Phone: 0300 123 6780
Email: developeras@lancashire.gov.uk
Your ref: 3/2026/0558
3/2026/0559
Our ref: 3/2026/0558/HDC/KW
3/2026/0559/HDC/KW
Date: 18 August 2026

Location: Moneymoon Preston Road Ribchester PR3 3YD
Proposal: Planning Permission for construction of a detached two-car garage within the curtilage of the Grade II Listed Building, demolition of cart shed attached to existing detached outbuilding and associated works including partial exposure of the culverted watercourse and provision of a new entrance.
Grid Ref: 372213 445288

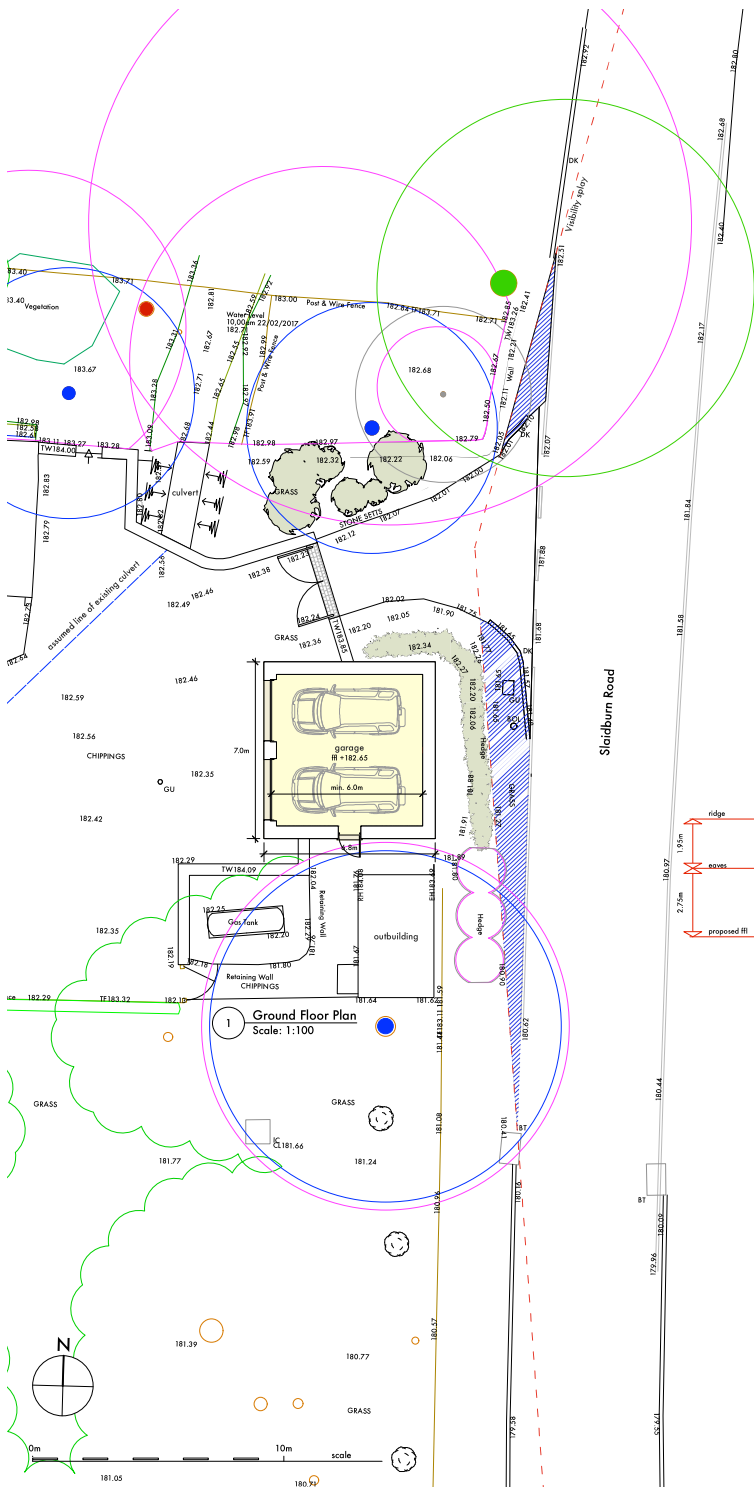
The LHA has reviewed the floor plans which show that the proposed garage meets the recommended minimum internal dimensions for a double garage, which is 6m in length and 6m wide. As such, it is considered acceptable to provide parking spaces.
